**WELWYN HATFIELD BOROUGH COUNCIL  
EXECUTIVE DIRECTOR - PLANNING, PUBLIC PROTECTION AND GOVERNANCE**

**Application No:** 6/2017/2774/HOUSE  
**Location:** 28 Brockwood Lane Welwyn Garden City AL8 7BG  
**Proposal:** Erection of single storey side and rear extension including alterations to openings  
**Officer:** Ms Lucy Hale

**Recommendation:** Refused

Drawing No: 4247-P01 Revision: B

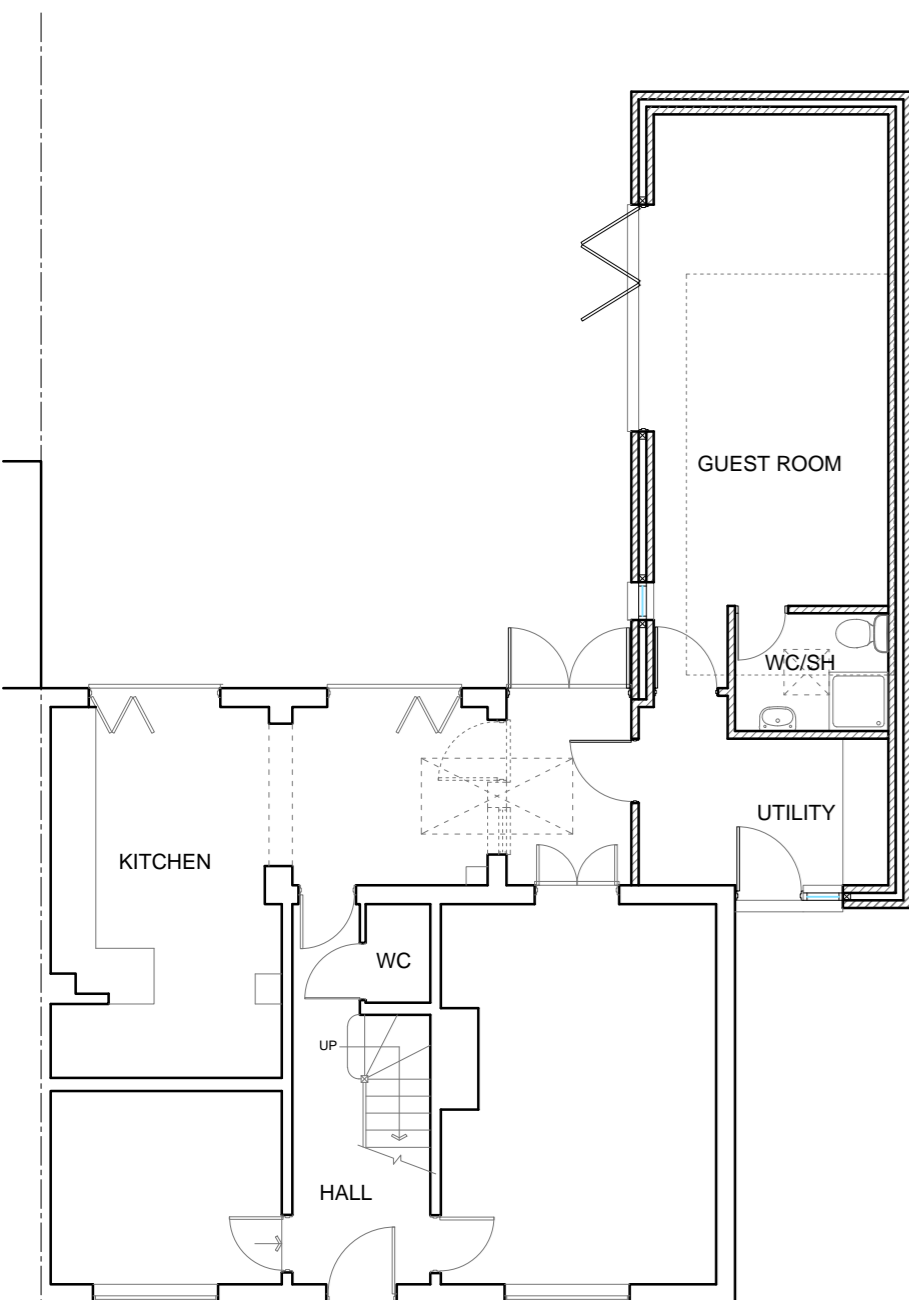
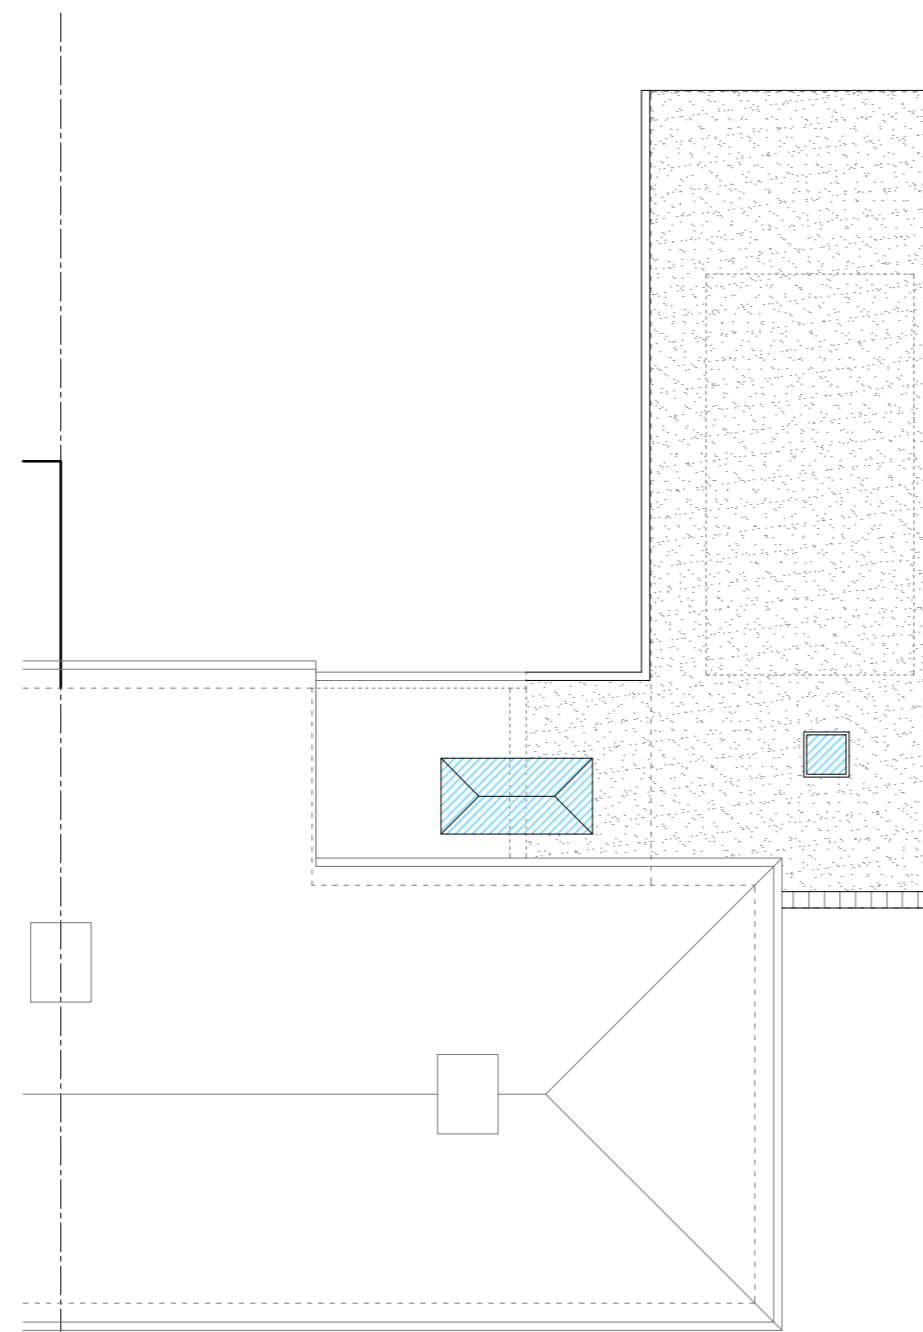
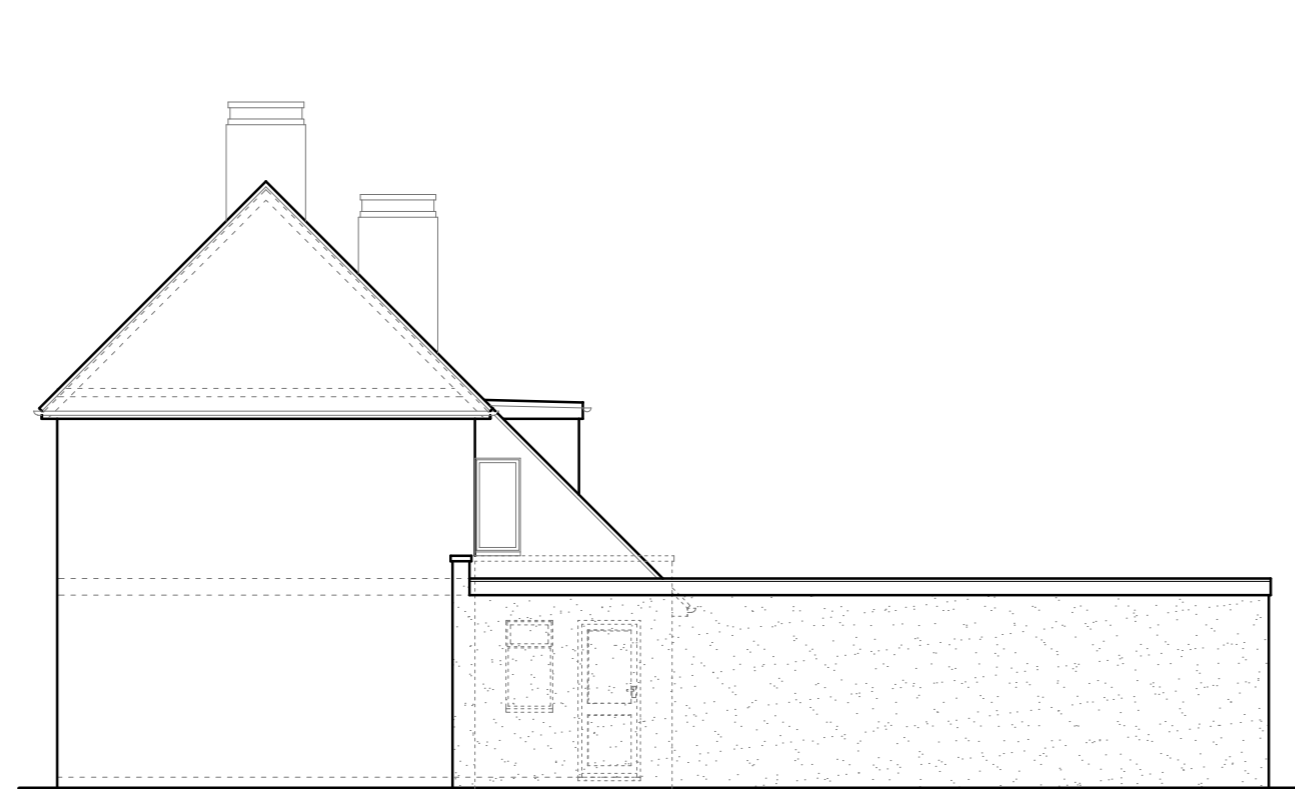
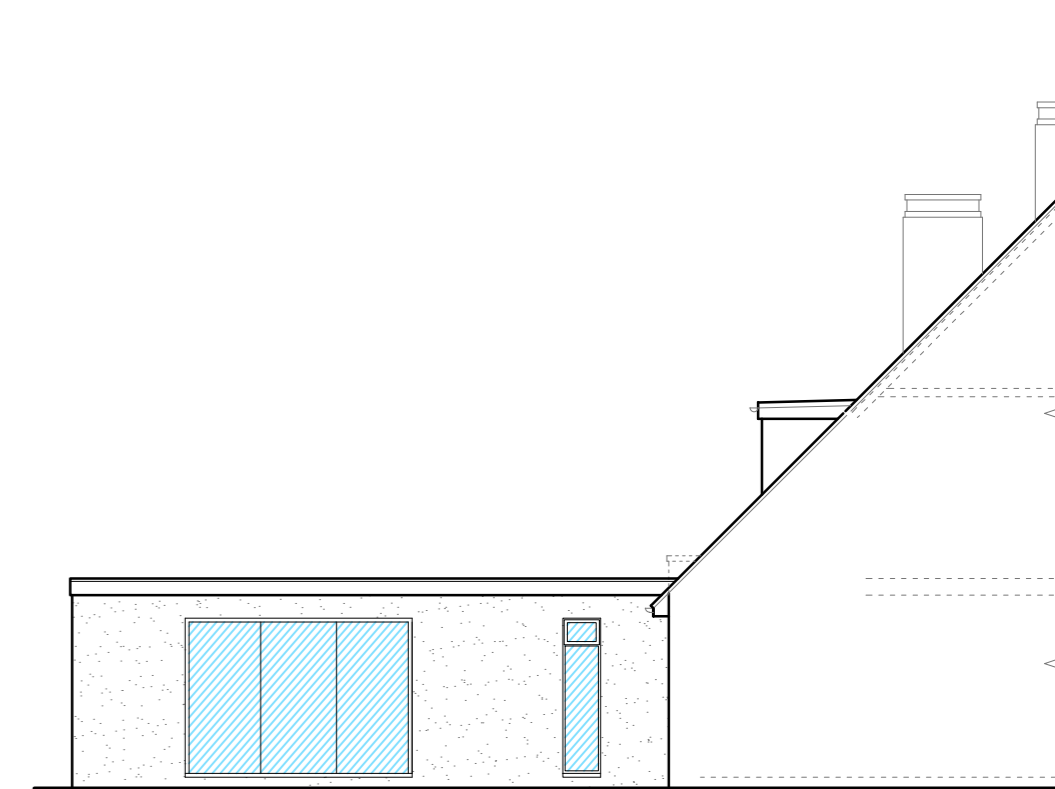
<p><b>Impact on neighbours</b></p>	<p>No neighbour representations have been received.</p> <p>The extension would be built along the shared boundary with No.26 Brockswood Lane. Whilst the extension would extend some depth into the rear garden, it would be of single storey nature at a height of approximately 2.7 metres with a flat roof. As a result of the outbuilding, separation distance and boundary treatments, it is not considered that the extension would result in a detrimental impact on the residential amenity of this neighbouring occupier in terms of loss of light, overbearing impact or privacy.</p>
<p><b>Access, car parking and highway considerations</b></p>	<p>The application property benefits from 4 bedrooms and is located in Zone 4 where a 4 or more bedroom property would require 3 on-site parking spaces. The application site benefits from a hardstanding which could accommodate 3 spaces which is an acceptable provision and no concerns are raised.</p>

The proposed rear extension, by virtue of its scale and excessive depth, would fail to appear subordinate in scale and respect the design and form of the original dwelling, The proposed extension would result in an incongruous addition to the application dwelling which that would be detrimental to the character and appearance of the Conservation Area contrary to Policies D1 and D2 of the Welwyn Hatfield District Plan 2005, the Supplementary Design Guidance 2005 and the National Planning Policy Framework 2012.

1. The proposed rear extension, would result in an excessive depth of built form in relation to the original dwelling which would fail to remain subordinate in scale and respect the character and form of the original dwelling. The extension would result in an incongruous addition that would fail to maintain and preserve the character and appearance of the Garden City Conservation Area, contrary to Policies D1 and D2 of the Welwyn Hatfield District Plan 2005, the Supplementary Design Guidance, Statement of Council Policy 2005 and the National Planning Policy Framework 2012.
